# Comment Response Memo

1 March 2023

Strand Residence – 2207-019

6950 Maker St

SOUTH ELEVATION

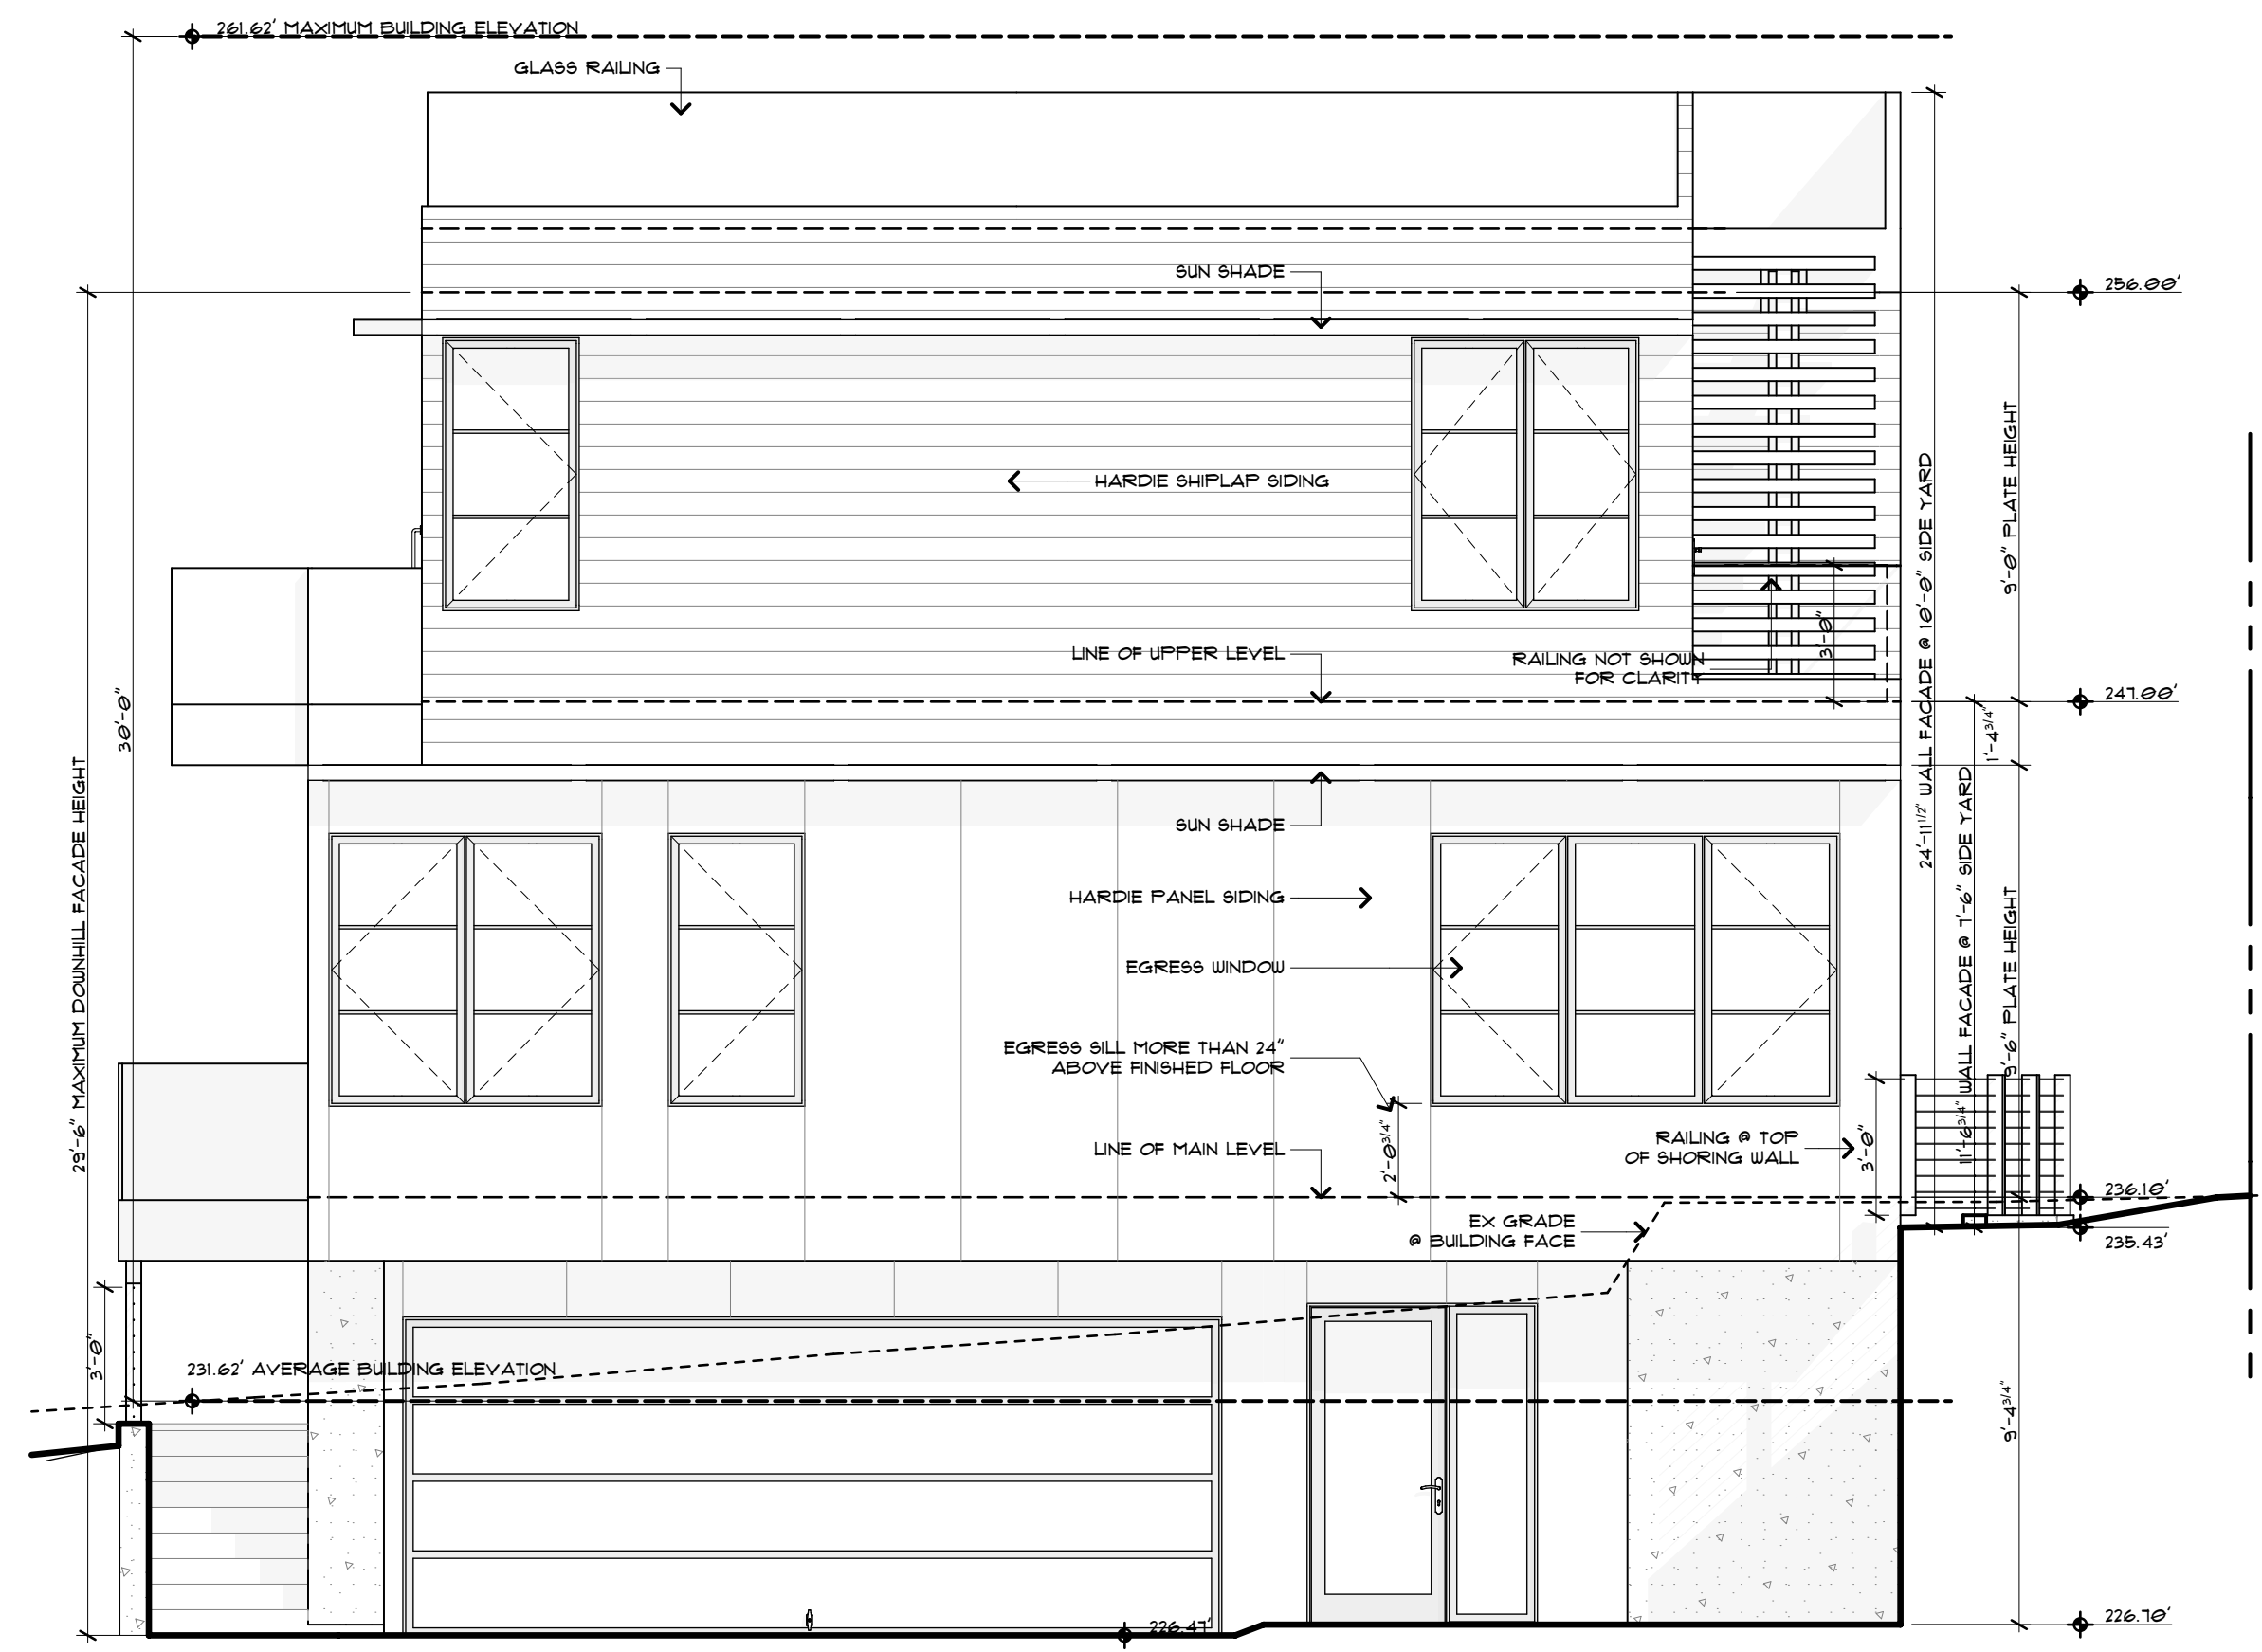
4. Maximum Building Height on Downhill Façade is shown on the South Elevation of the updated drawings and is measured at 29'-6" to the top of the wall supporting the roof framing per MICC 19.02.020(E)(2)
